From: Simon Davis
Sent: 30 July 2020 14:45
To: 'Maddi Simpson' [REDACTED]
Cc: Leona Hannify [REDACTED]
Subject: RE: BN/50/20/PL Land W of Fontwell Avenue - Design Comments

Garage
Floor Plans and Elevations

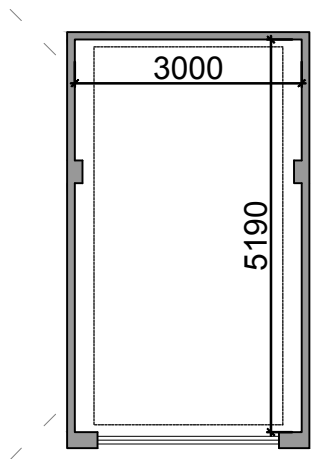
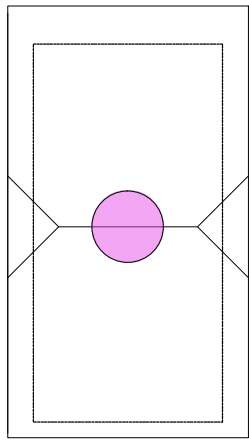
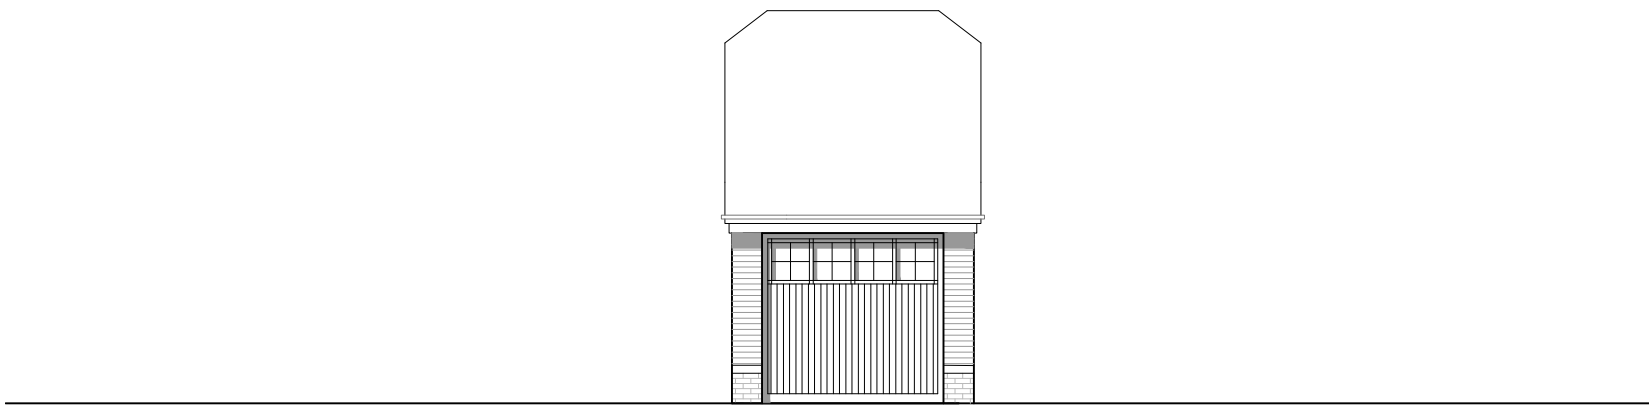
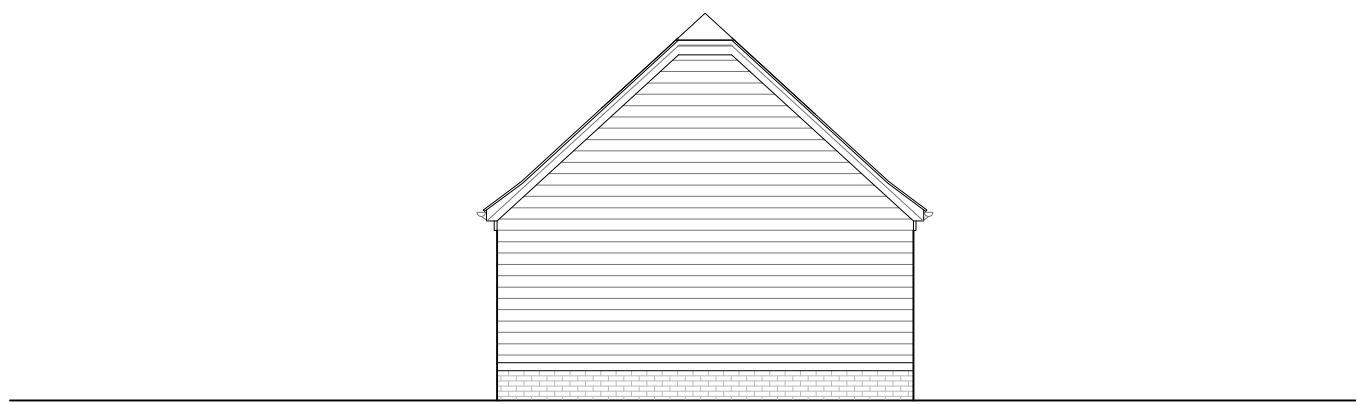
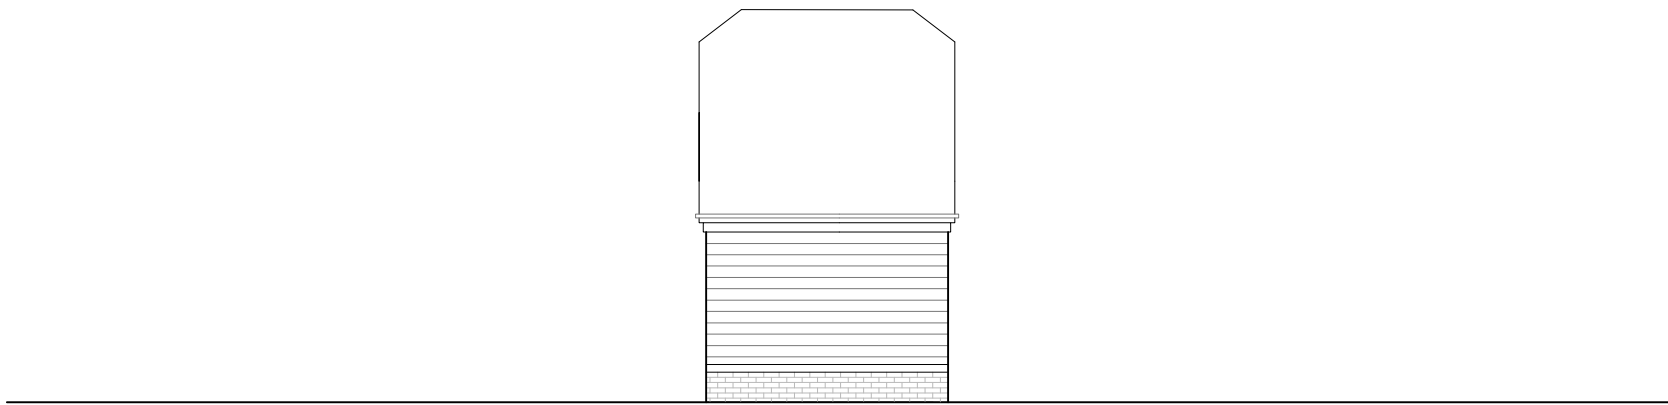
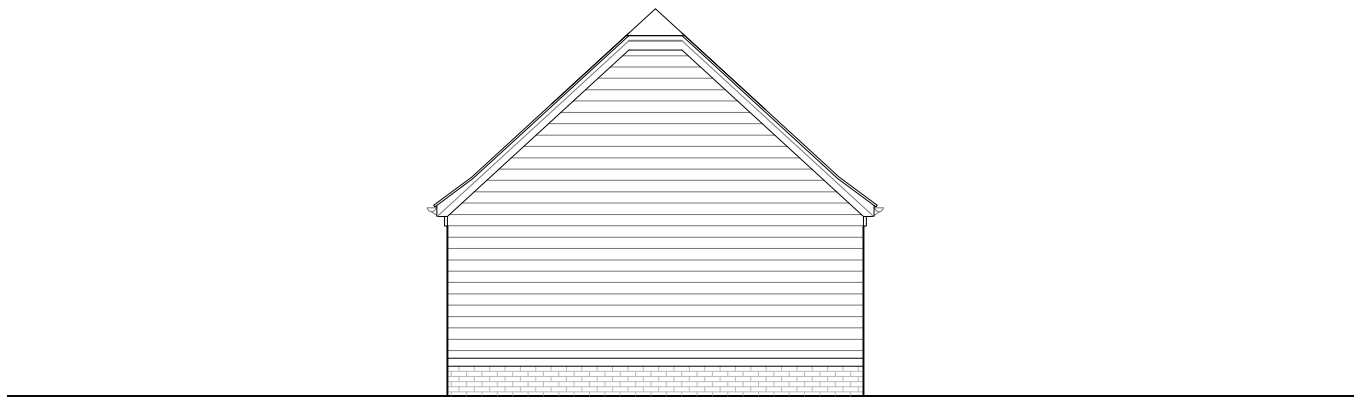
Highways have also provided the attached comments. You will see they require further information. Their summary is: *The garage floor plans do show substandard length and these should be amended to meet with local guidance (3m by 6m). In terms of the DfS forms, further clarification and justification should be provided as per the Highway Design/ Agreements Project Manager comments outlined above and the forms re-sent in Microsoft Word format.*

I had not noted the garage sizes previously. I advised you that garages are treated as half a space per our SPD but this is only if they are at least 3m by 6m. Therefore, if retained as they are, none of the garages will be counted as parking spaces.
